Active
Travel
England

Active Travel England Planning Response Detailed Response to an Application for Planning Permission

Application Ref: 2024/61/92235/W

Site Address: Land off Blackmoorfoot Road and Felks Street, Crosland Moor, Huddersfield, HD4 7AD

PROW LINK PATH PROPOSED DESIGN

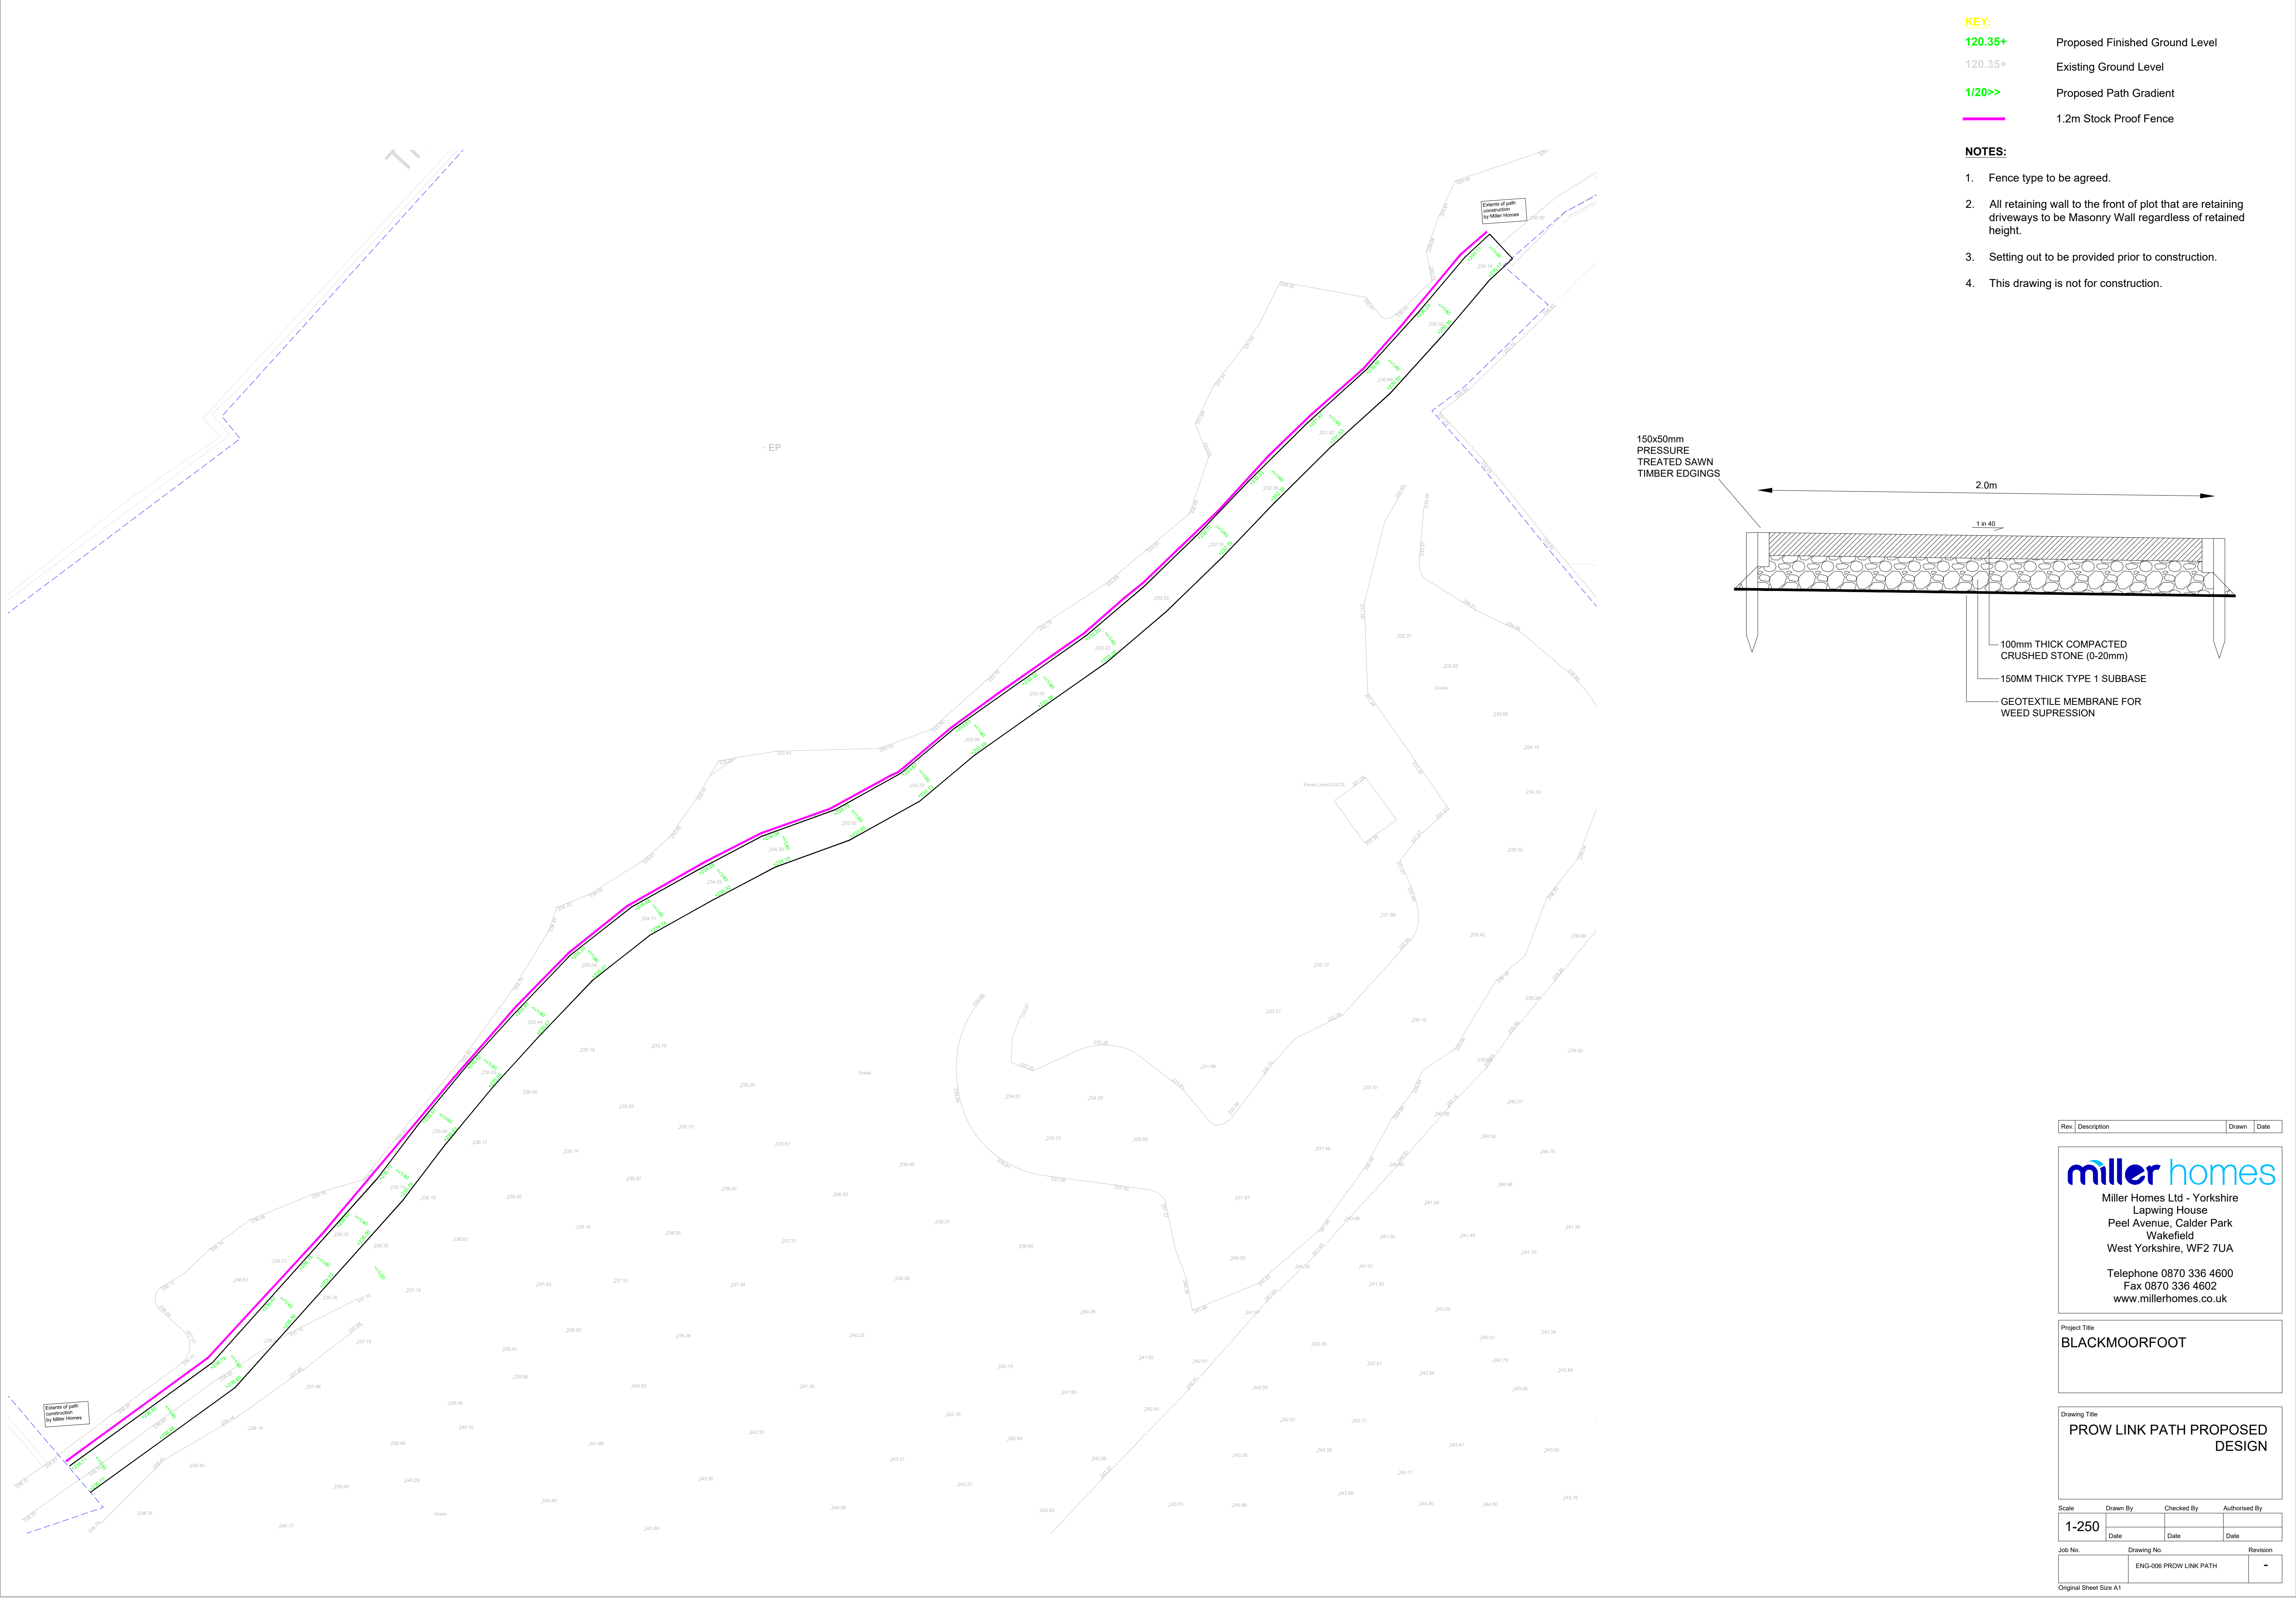
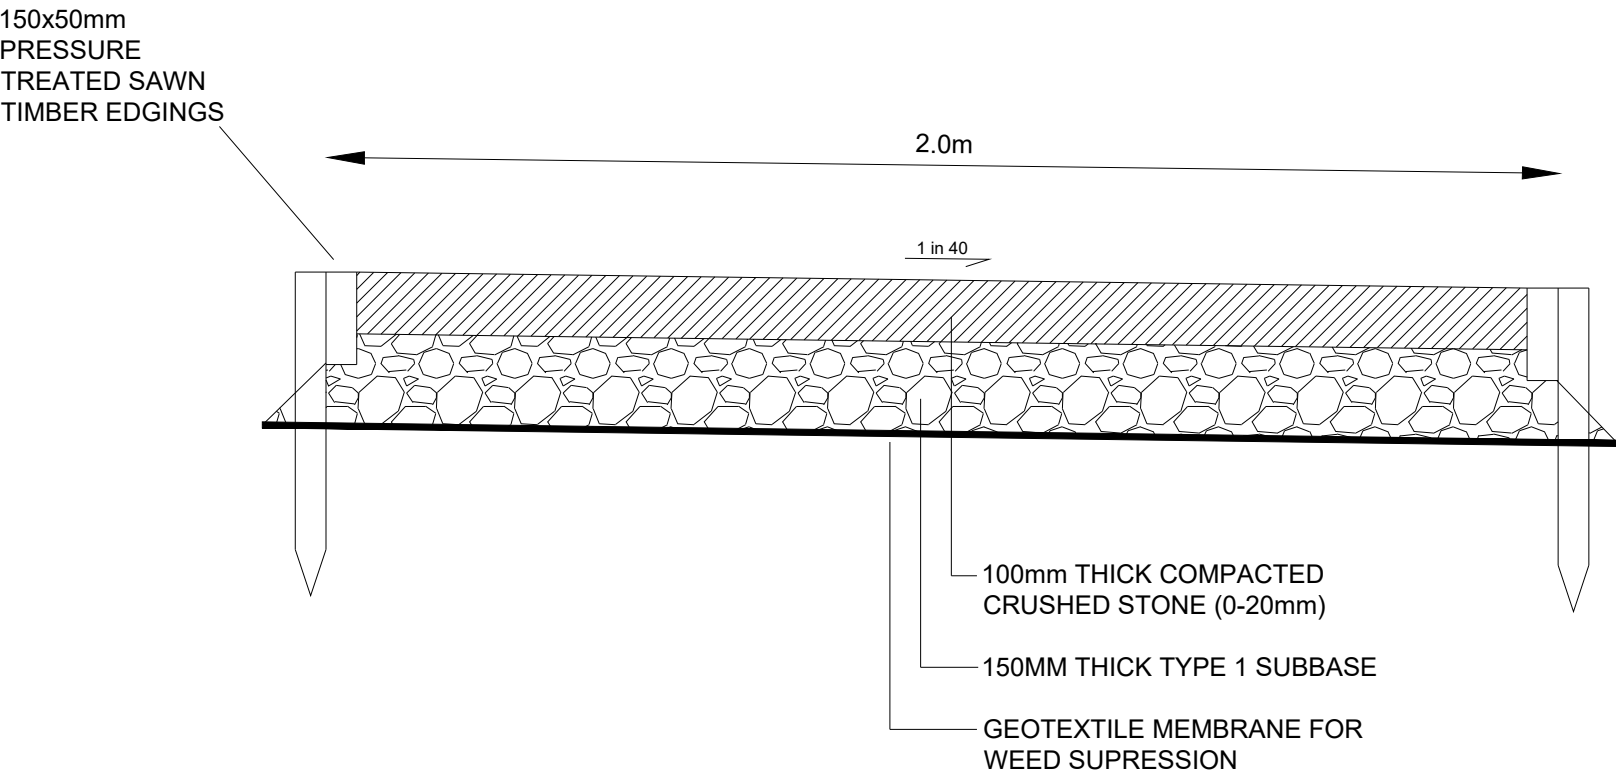
The crossing designs requested have not been included in the new plans and therefore this issue is still outstanding. The Pedestrian Footpath Link Levels plan includes some information on one crossing seeming to show a raised table possible on a secondary residential street to the south west of the site. Please can more information be provided to present a comprehensive crossing design for the whole site.
